Re: ABB Expansion; Traffic Impact Study Comment Response Letter

Thank you for the Traffic Impact Study review comments memo dated December 19, 2023 for the ABB Expansion project. The purpose of this letter is to provide responses to the comments to assist NMDOT with review of the traffic study.

FIGURE 11
ABB EXPANSION
ALBUQUERQUE, NEW MEXICO
RECOMMENDED GEOMETRY AND CONTROL

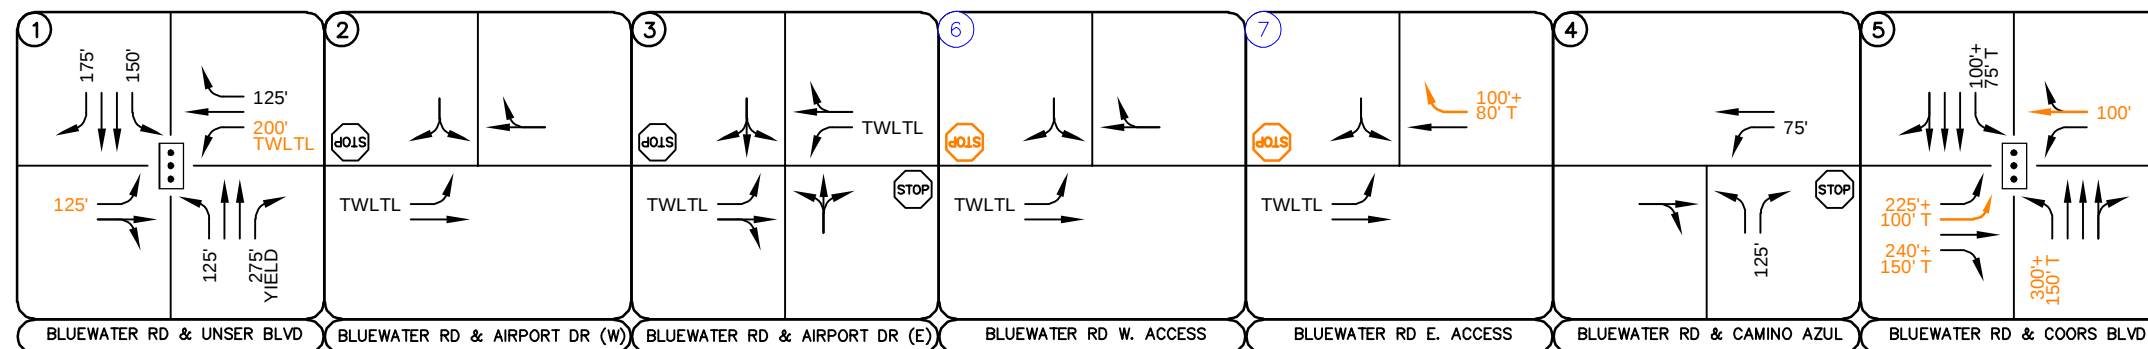
Comment #14: Page 42 – Can you provide mitigation scenarios at NM 45 and Bluewater to include.
1) Modify westbound lane designations from left/thru and right to left and thru/right; 2) dual EBL; and
3) signal timing recommendations as shown below.

Response: The intersection of Bluewater Road and Coors Boulevard was updated with the above geometric improvements. Signal timing improvements were not necessary based on the intersection operating acceptably with the proposed lane configuration. However, these may be implemented in order to improve safety at this intersection.
